1brookside close
Ferring
Bn12 6qd

RE PLANNING APPLICATION FG/66/18PL OBJECTION

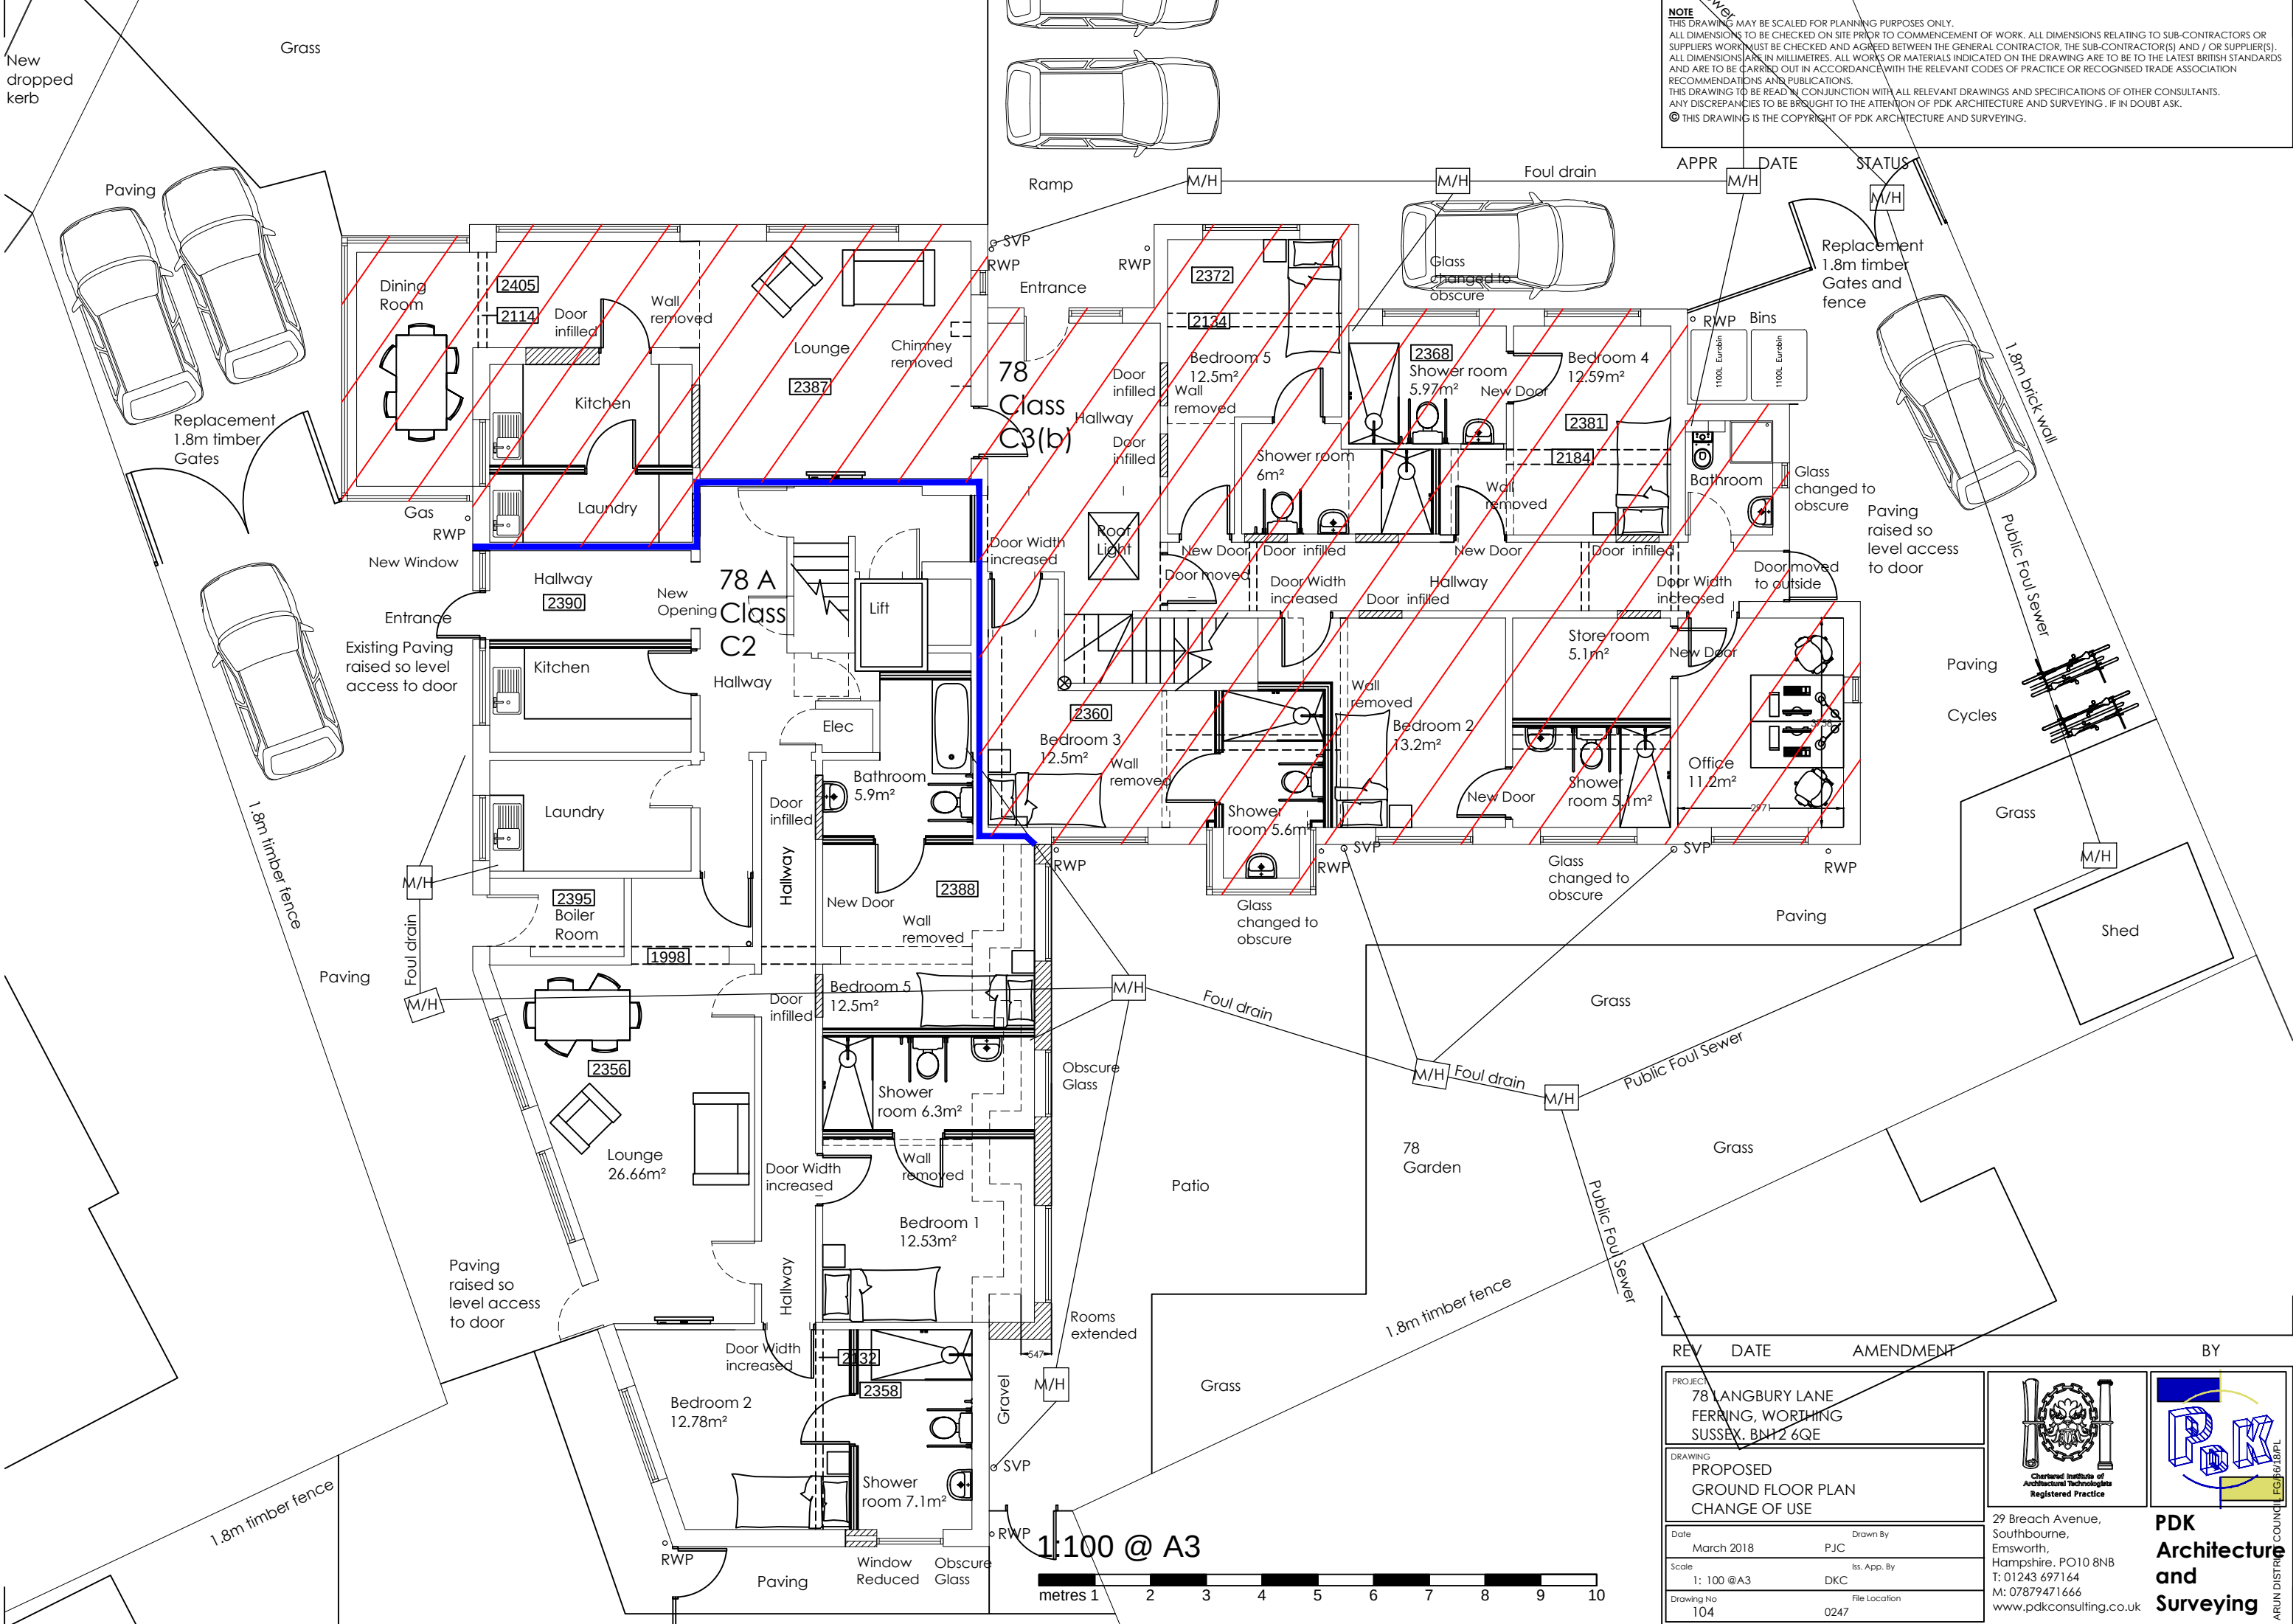
I HAVE NOW SEEN THE PLANS AND UNDERSTAND THAT A CHANGE OF USE IS ALSO ASKED FOR PLUS DROPPING THE KERB IN BROOKSIDE CLOSE THUS CONTRADICTING ONE OF OUR COVENANTS, PLUS THREE CARS PARKED SO CLOSE TO MY PROPERTY, IN FACT OUTSIDE MY

LOUNGE WINDOW, WITH A STAFF OF TWENTY DOING SEVERAL SHIFTS, INCLUDING NIGHTS AND EARLIES WILL SEVERELY DISRUPT MY LIVING. I WOULD ALSO ADD, THAT TWO CARS PARKED SIDE BY SIDE WILL BE EXTREMELY TIGHT TO GET OUT OF, PLUS ANOTHER CAR IN FRONT OF THAT.

IN THEIR PLANS THEY MAKE THE DISTANCE BETWEEN OUR PROPERTIES, IE 78 LANGBURY LANE AND 1 BROOKSIDE CLOSE, SEEM MUCH BIGGER THAN THEY REALLY ARE.
